WEST SUSSEX COUNTY COUNCIL CONSULTATION

TO:	Arun District Council FAO: Amy Myer
FROM:	WSCC - Highways Authority
DATE:	2 November 2021
LOCATION:	12 Cornwall Road, Littlehampton, BN17 6EE
SUBJECT:	LU/315/21/PL Change of use from (C3) Dwelling house to 7 bed House in Multiple Occupation (Sui Generis) (resubmission following LU/240/21/PL). This site is in CIL Zone 4 and is CIL Liable as a House in Multiple Occupation.
DATE OF SITE VISIT:	N/A
RECOMMENDATION:	Advice
S106 CONTRIBUTION TOTAL:	N/A

Block Plan
Scale 1:500

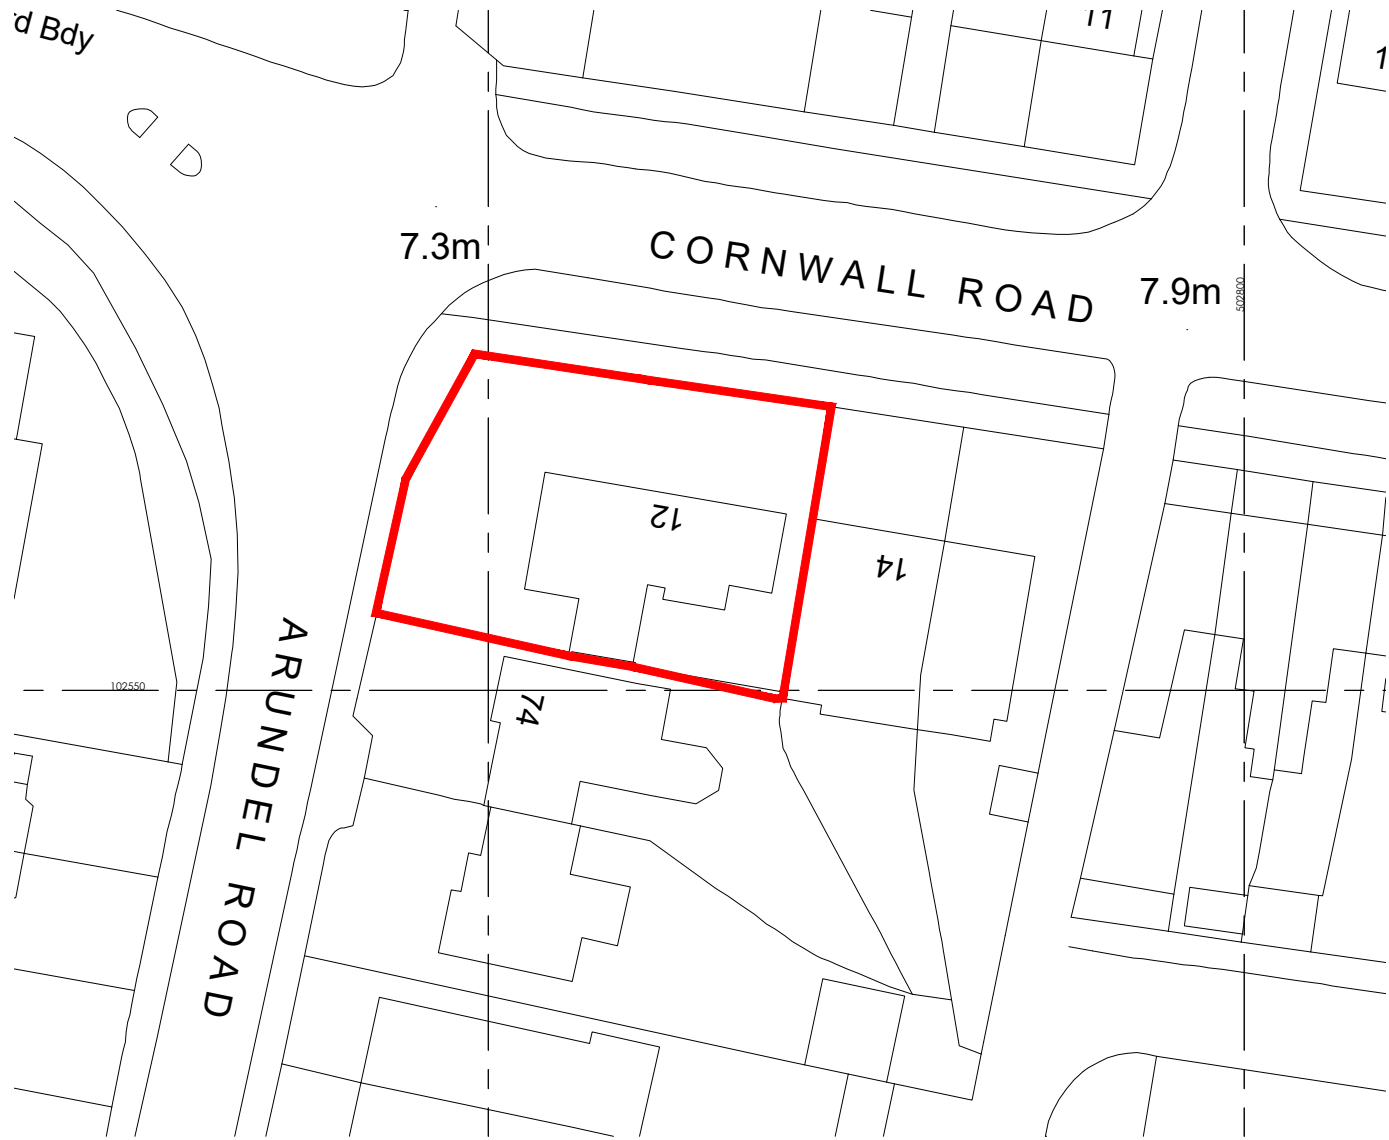
The applicant proposes two car parking spaces for this development. For HMOs, the LHA would expect a parking provision of 0.5 spaces per bedroom: totalling 3-4 spaces for this development. Consequently, any overspill parking would have to be accommodated on-street. Whilst on-street parking is limited in the area, there are comprehensive parking restrictions in place prohibiting vehicles from parking in places that would be a detriment to highway safety. The LHA does not anticipate that the shortfall of two parking spaces would result in a detrimental highway safety concern. However, the LPA may wish to consider the potential impacts on on-street parking from an amenity point of view.

On-site turning does not appear achievable, so vehicles may have to exit the site in a reverse gear. However, this is the existing arrangement, which is not anticipated to result in a highway safety concern.

The applicant has demonstrated cycle parking, with provision for eight cycles. Given the number of bedrooms, the LHA considers the proposed cycle parking provision to be sufficient. The inclusion of secure and covered cycle parking helps promote the use of sustainable transport methods.

No part of the development shall be first occupied until covered and secure cycle parking spaces have been provided in accordance with plans and details to be submitted to and approved by the Local Planning Authority.
